M3 Junction 9 Improvement

Scheme Number: TR010055

7.12.1 Statement of Common Ground with Winchester City Council (Rev 1)

7.12.1 STATEMENT OF COMMON GROUND WITH WINCHESTER CITY COUNCIL

**DRAWING TITLE**  
 FIGURE 2.5 - THE SCHEME: TEMPORARY TRAFFIC DIVERSION ROUTES  
 APFP REGULATIONS 5(2)(a)  
 SHEET 1 OF 12  
 DOCUMENT REFERENCE 6.2

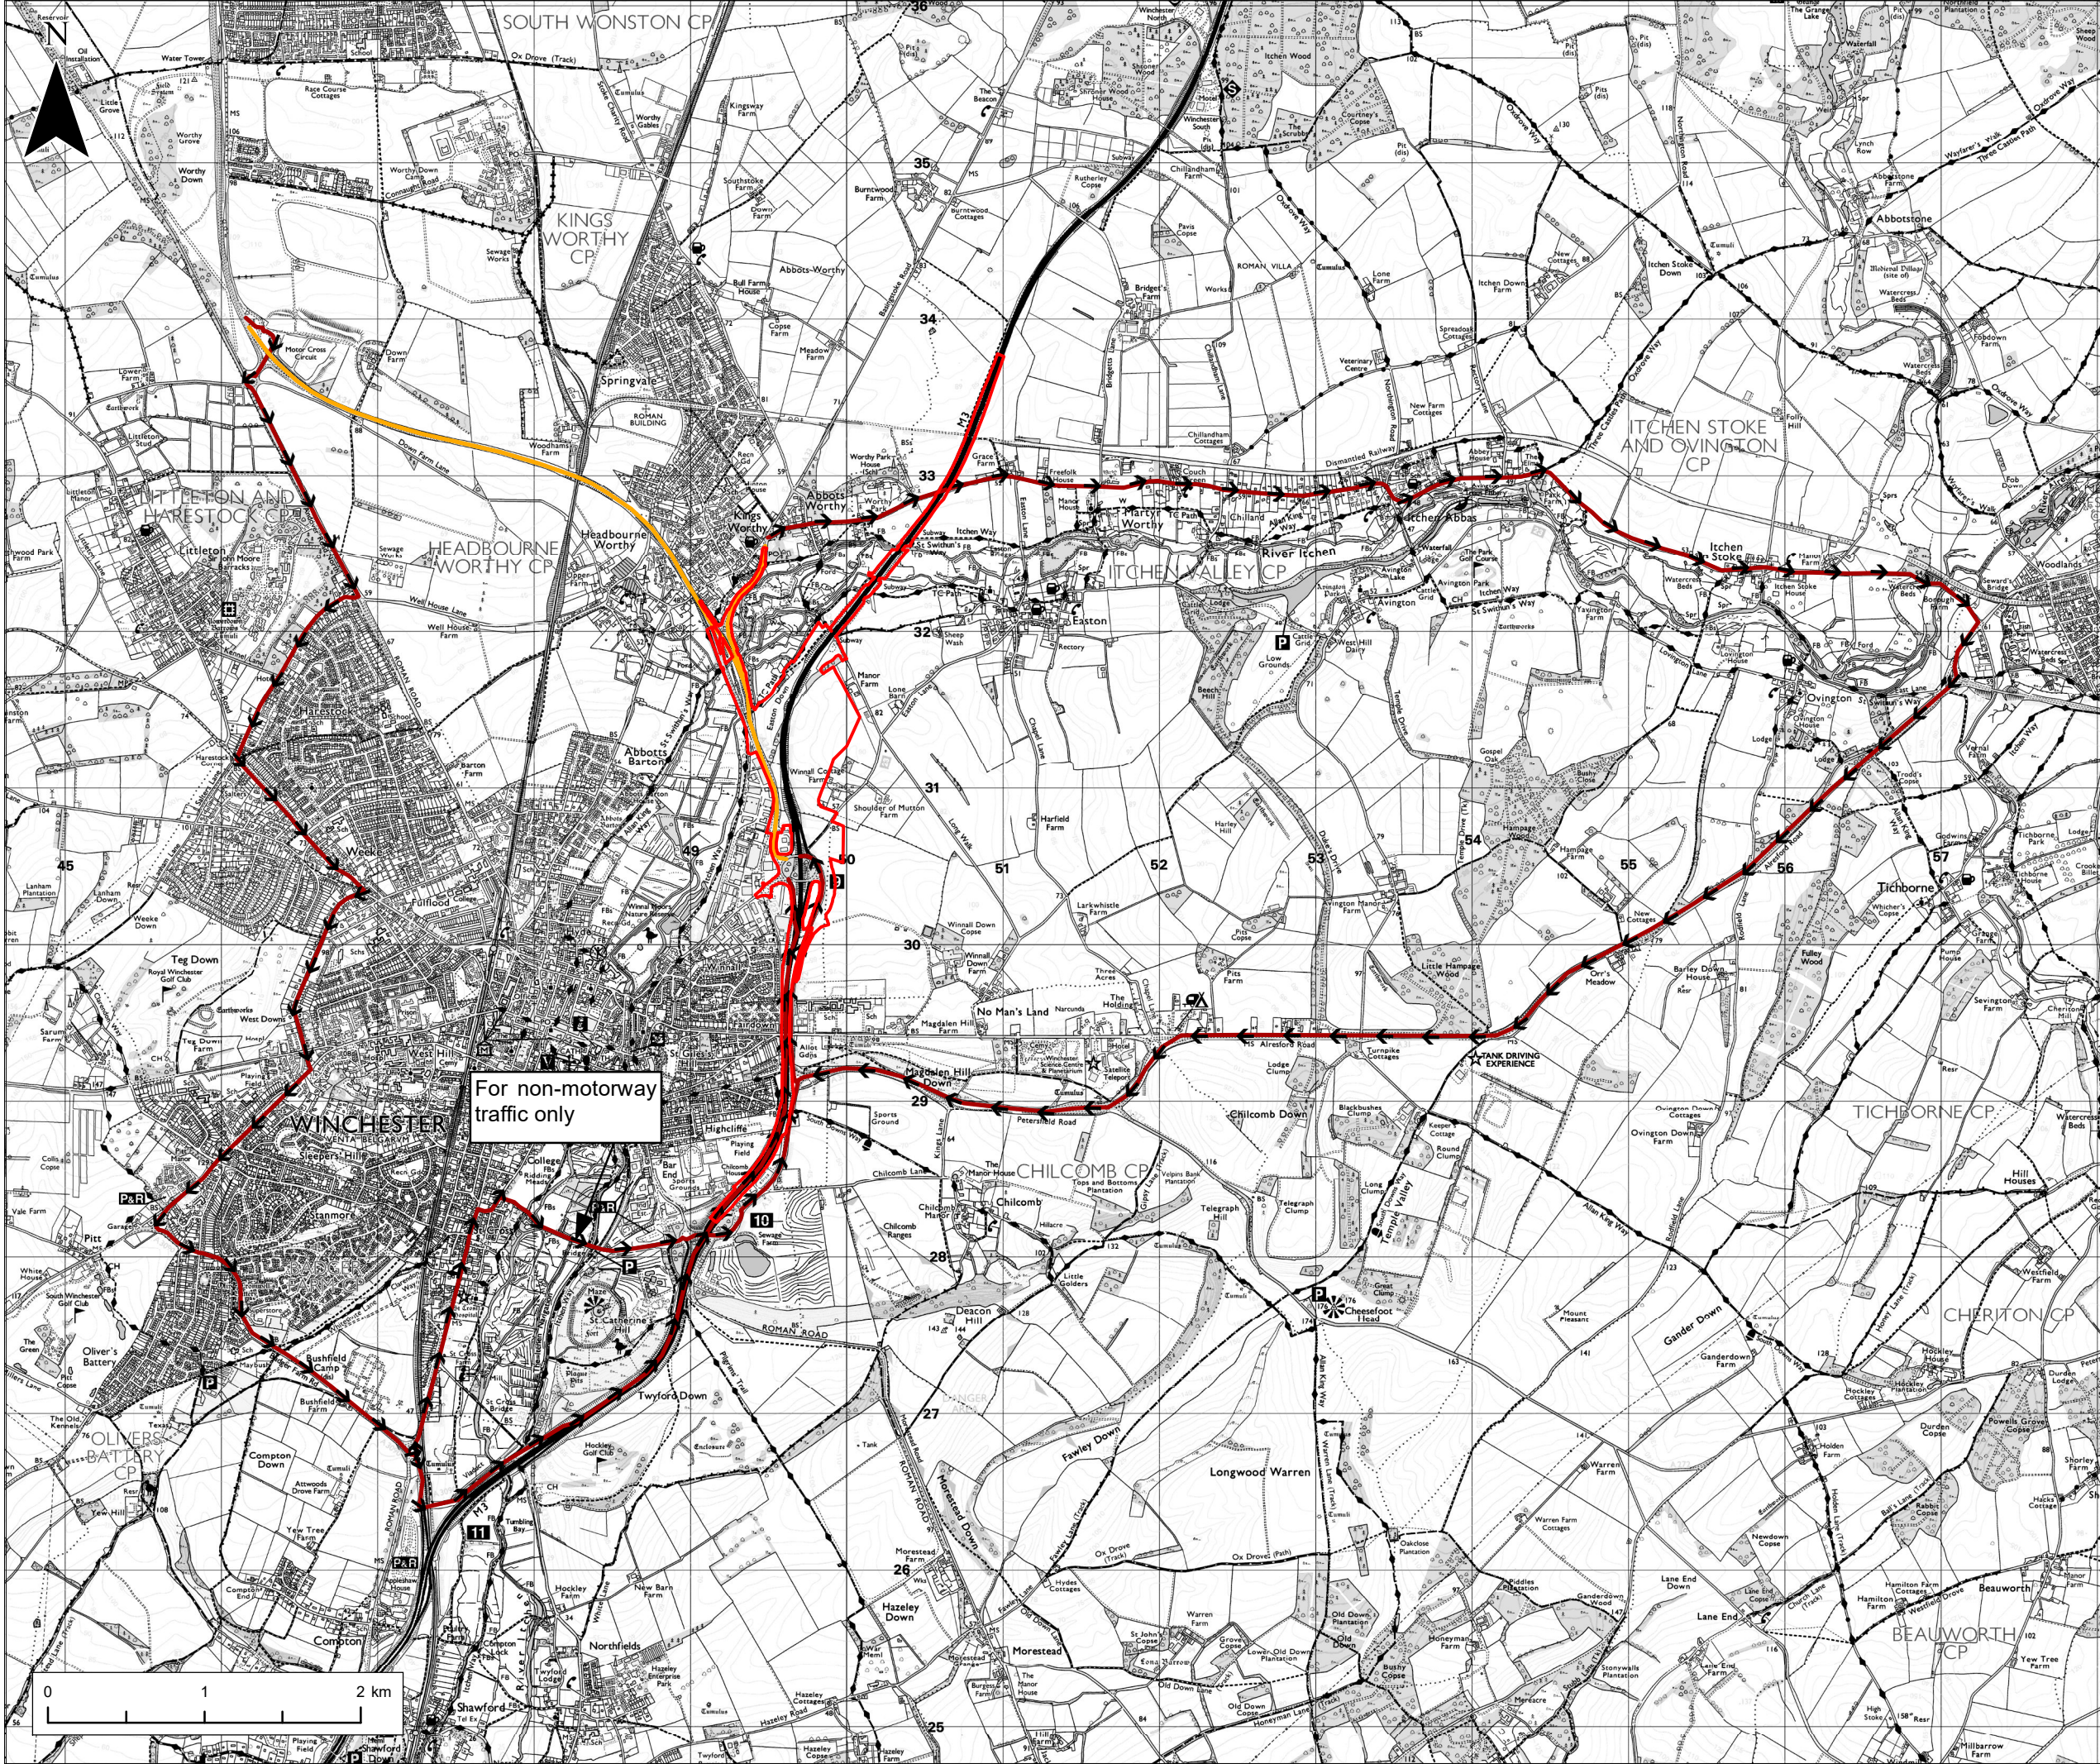
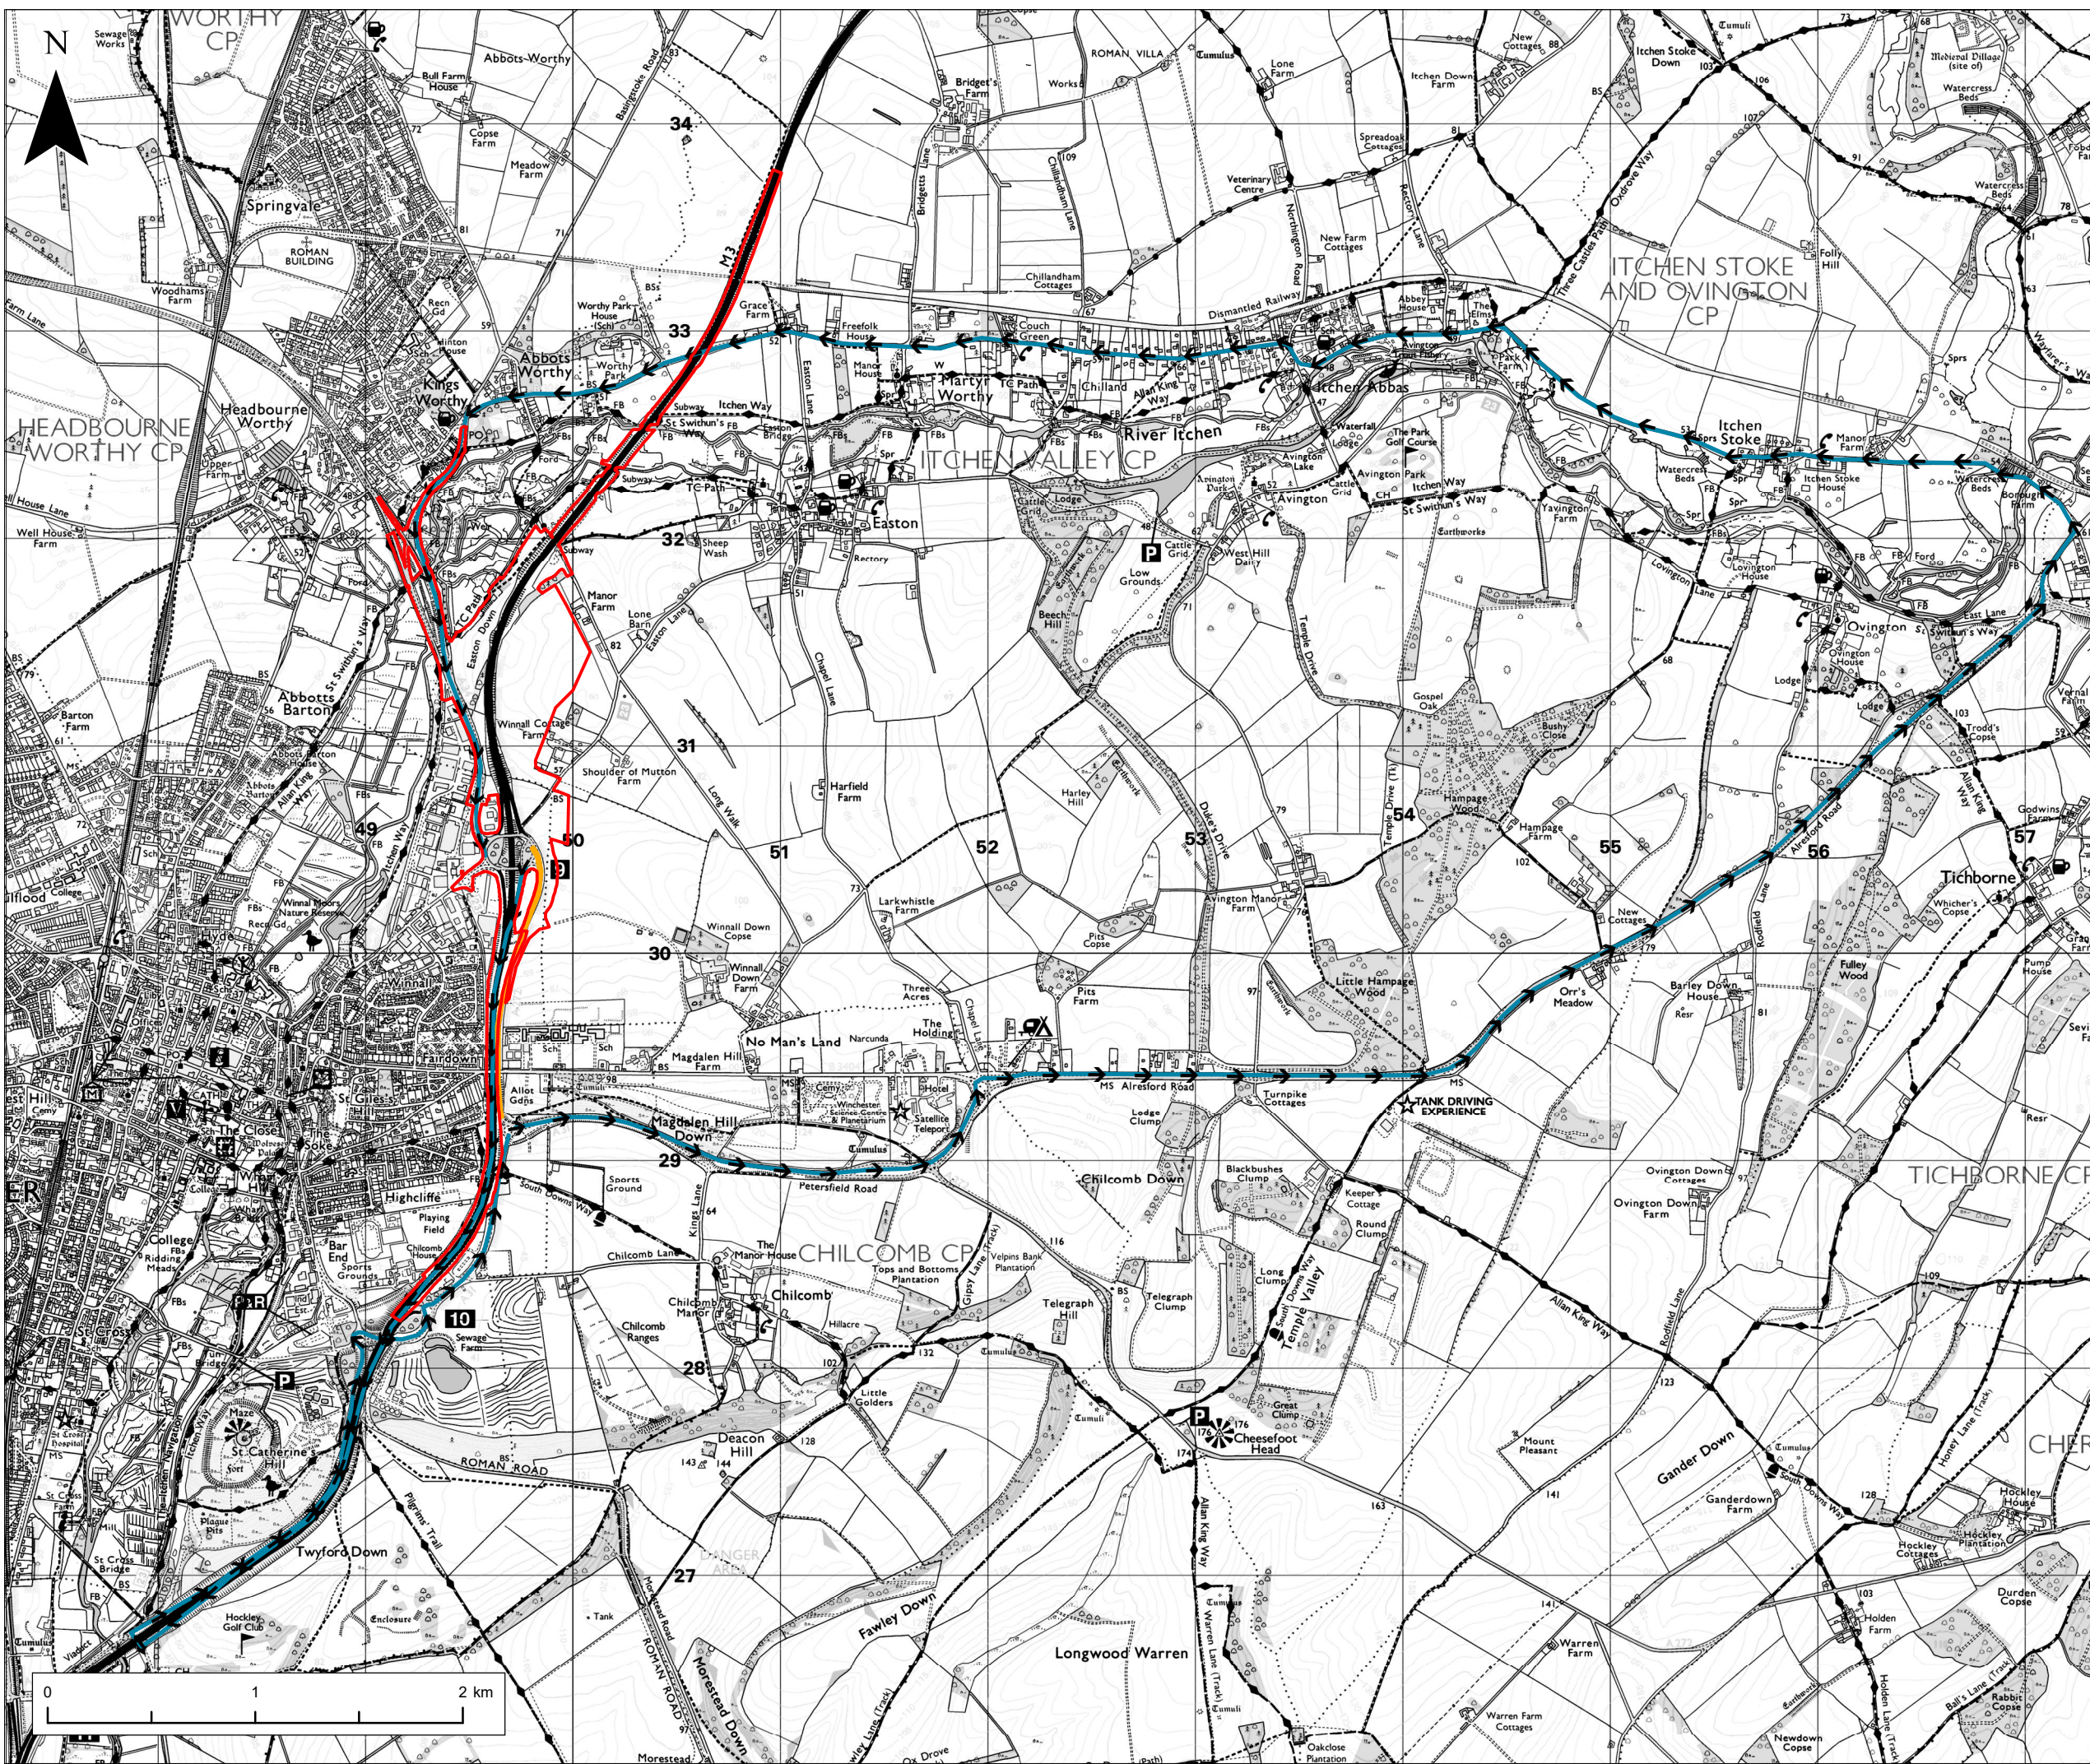
3.6	Mitigation Section 5.8 of Chapter 5 (Air Quality) of the ES (6.1, Rev 1) outlines the essential mitigation during construction.	Chapter 5 (Air Quality) of the ES (6.1, Rev 1)	Although this has been covered in Environmental Statement - the air quality and noise impacts assume indicative diversion routes are used that in reality do not seem to realistic to likely resultant patterns at such times. At ISH2 it was confirmed that discussions will be held between the Highway Authority and Applicant concerning advanced positioning of signs and general methods to ensure compliance with	National Highways is reviewing Winchester City Council's recent comment on this matter.	Under Discussion	18 August 2023
